From: Hayley Backley 
Sent: 07 June 2018 11:55
To: Neil Crowther
Cc: Anita Gardner
Subject: EP/52/18/PL

Both of these vehicles are parked outside of the proposed entrance to the new development that is being considered on the plot of no 9 Lime Tree Close.

TITLE: Swept Paths March 2018 SITE: Limetree Close East Preston	Drawing: Vehicle Swept Paths	Autoturn Vehicle Swept Path Analysis & Visibility Data Prepared by Autoturn Specialists in Simulated Vehicle Swept Paths
	Drawing Reference: LT.SWEPT.001	
	Scale: On A2 1:200 / as bar

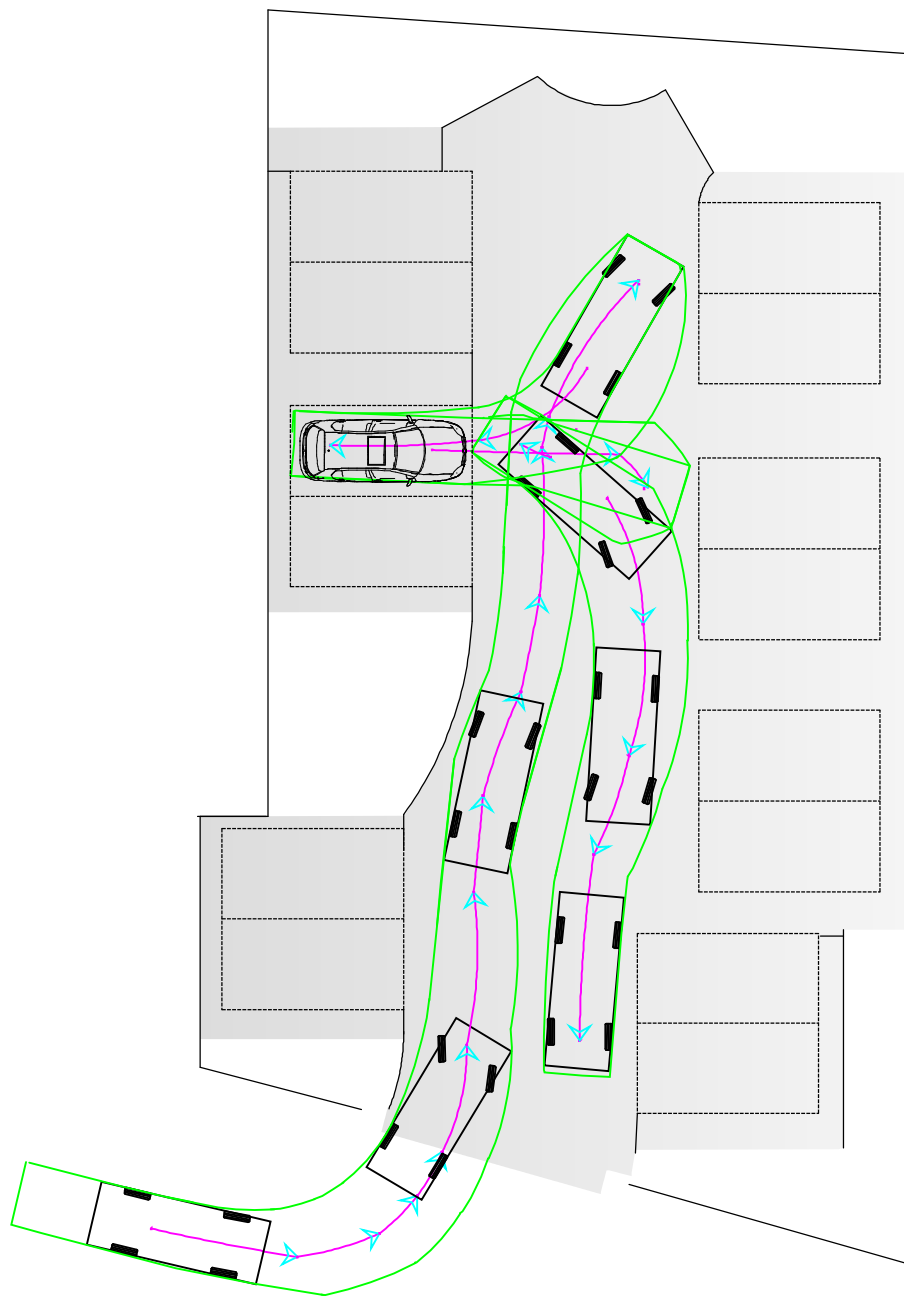
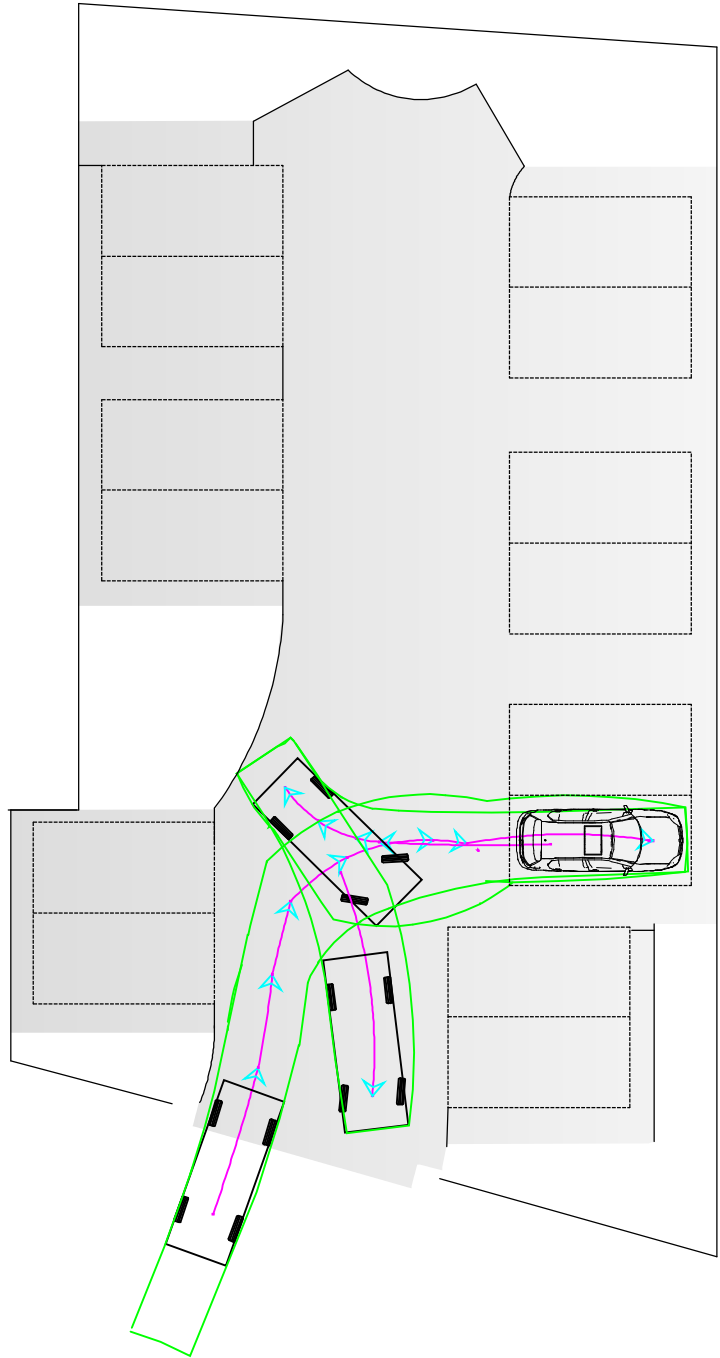
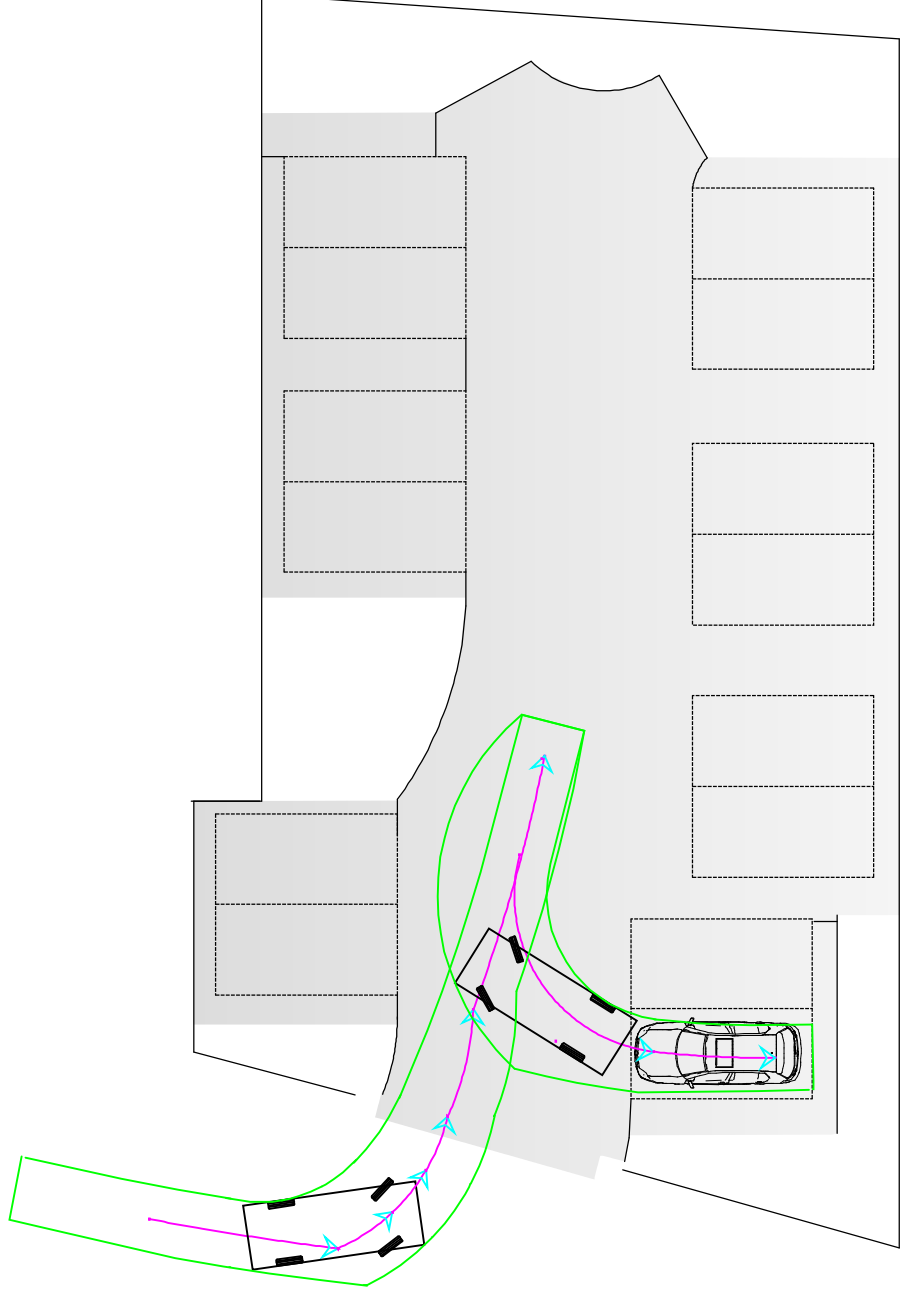
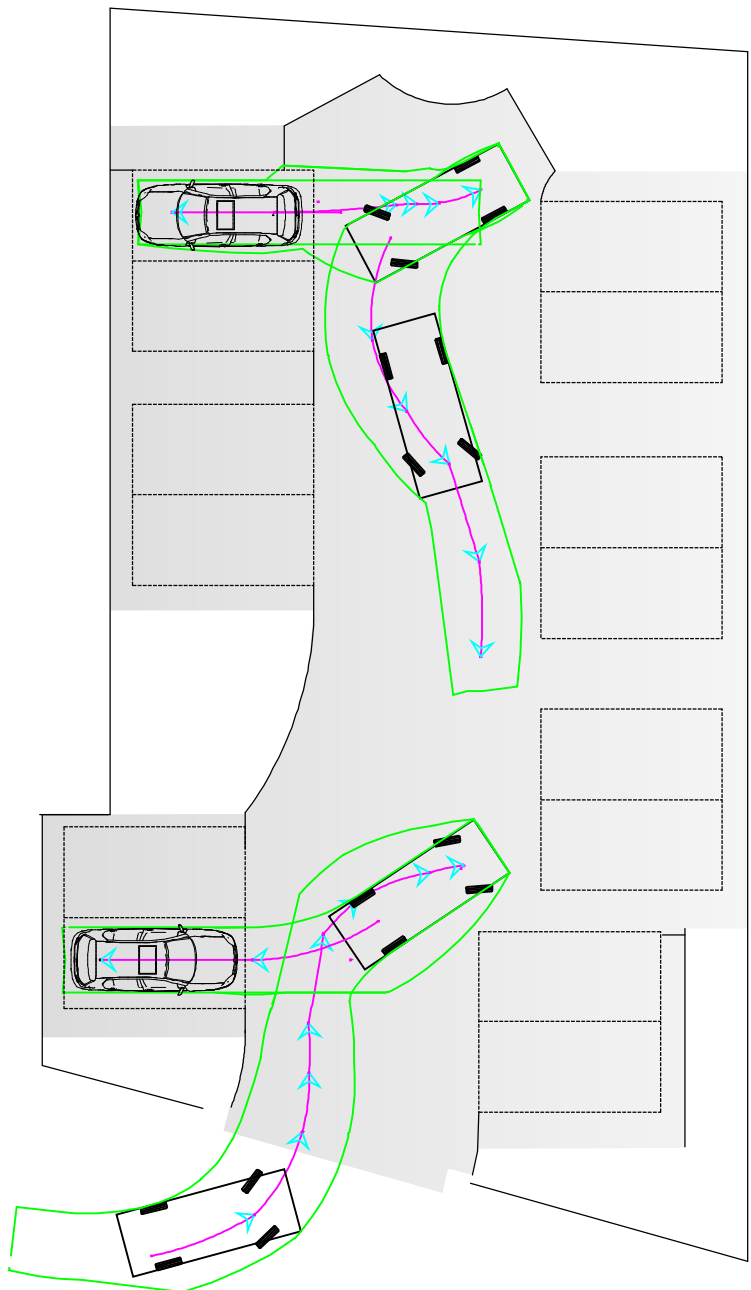
This with the other photographic evidence that I have sent in demonstrates clearly, that the proposed site entrance is not a safe and sustainable environment for the new development as there is no provision for a footpath? and the entrance would be very often obscured. The updated housing plan, suggests young families are the target buyers. The third non "bedroom" listed as a study, would suggest also a useful nursery. This smaller housing so close to a school would attract families with children, who with the present plans have no safe way of entering and exiting the development on foot. We the residents continue to highlight that the proposed access to the new development is not appropriate and should at the very least be placed at the entrance of LTC or directly off of The Street.

The photographic evidence that I have submitted over the last few weeks, demonstrates the lack of space for parking/manoeuvring and access. The proposed development being accessed from LTC will only make this situation worse and unsafe.
